Meeting Minutes

Project: NCDOT STIP Project U-5791

Subject: U-5791 CP1/CP2 Jacksonville Parkway Extension Merger Meeting

Date and time: 08 September 2021 at 10:00AM

Figure 8. Corridor Concept Alternative 2a: New Southeastern Alignment and Ramsey Road Widening

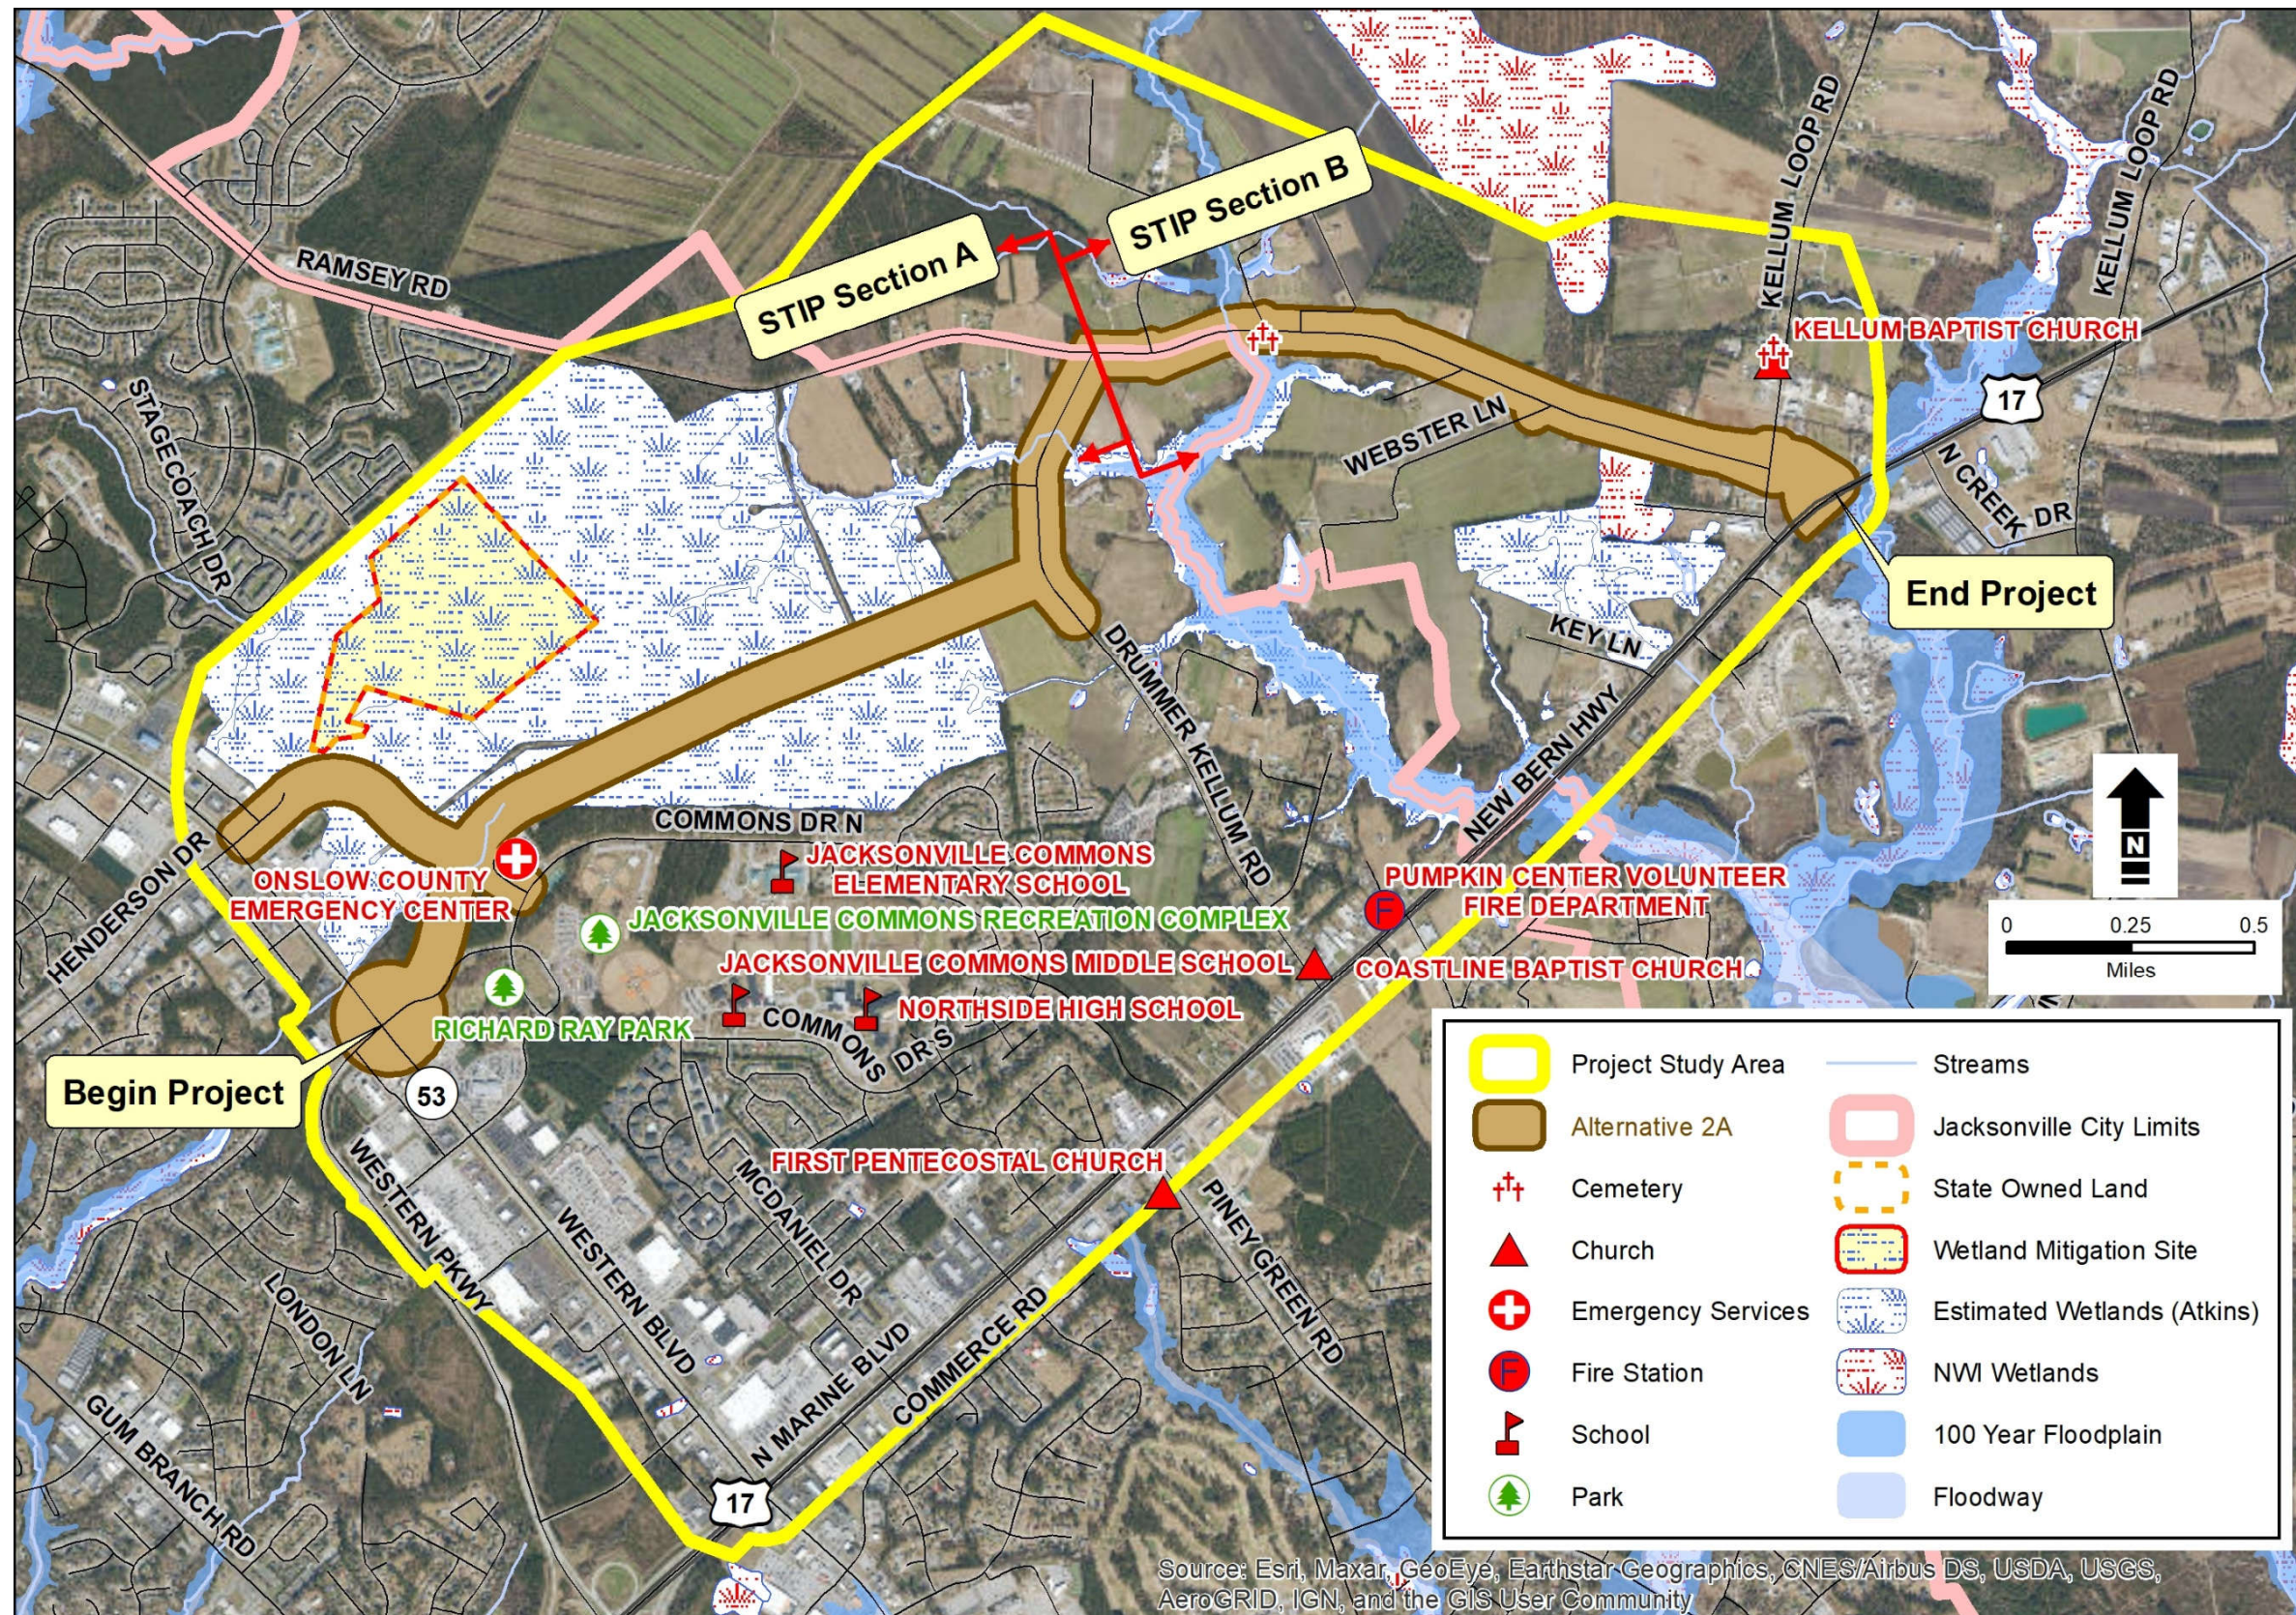
Somerville expressed concerns as to why a 500-foot corridor was used in the second screening, and only a 250-foot corridor was used in the third screening when different alternatives were analyzed in each of the screenings. Boot explained that this was an effort to better define impacts from the 2nd screening to the 3rd screening. It was confirmed that more information regarding impacts for Alternative 2a be included. Cathy Brittingham (NCDEQ-DCM) also stated that the

The Merger Team agreed that another meeting would need to be held to review additional information for Henderson Drive in the Purpose and Need. Impact data for Alternative 2a and a new City of Jacksonville alternative connecting Alternative 2b to Ramsey Road will also be developed.

Figure 9. Corridor Concept Alternative 2b: New Southeastern Alignment

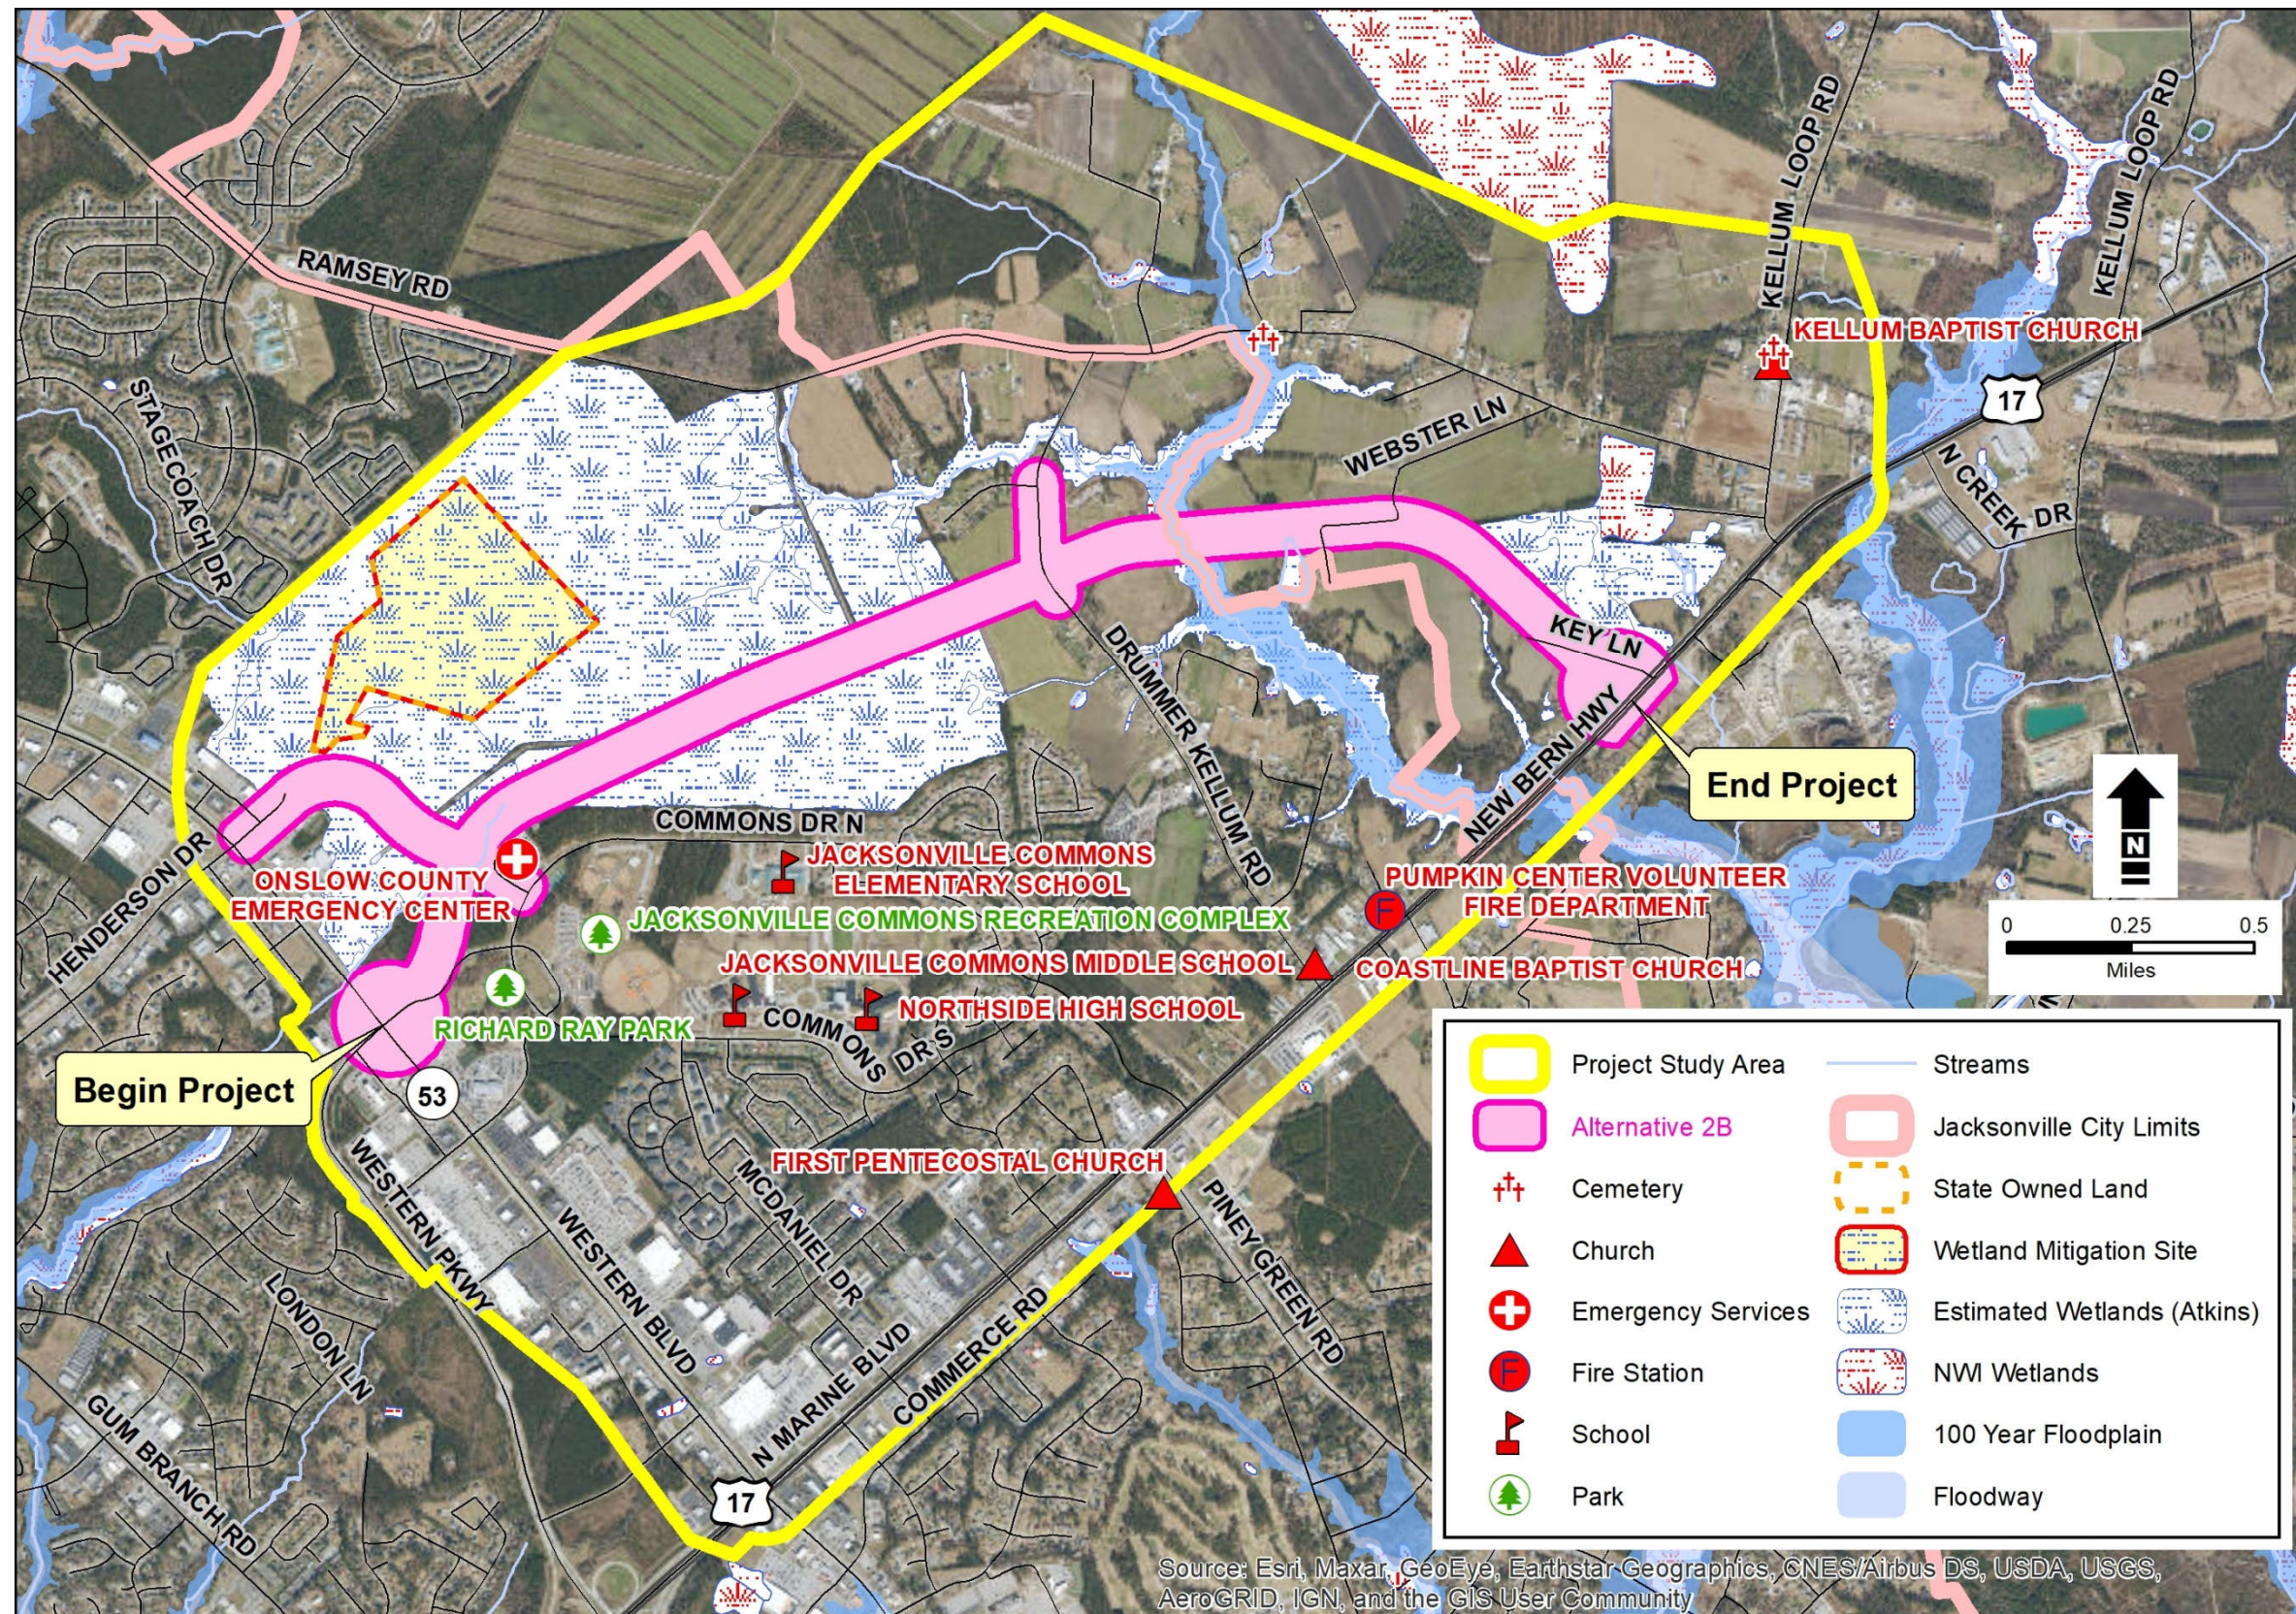
The City of Jacksonville has requested that a new alternative that follows a similar alignment of Alternative 2B but connects to Ramsey instead of US 17 was requested to be analyzed.
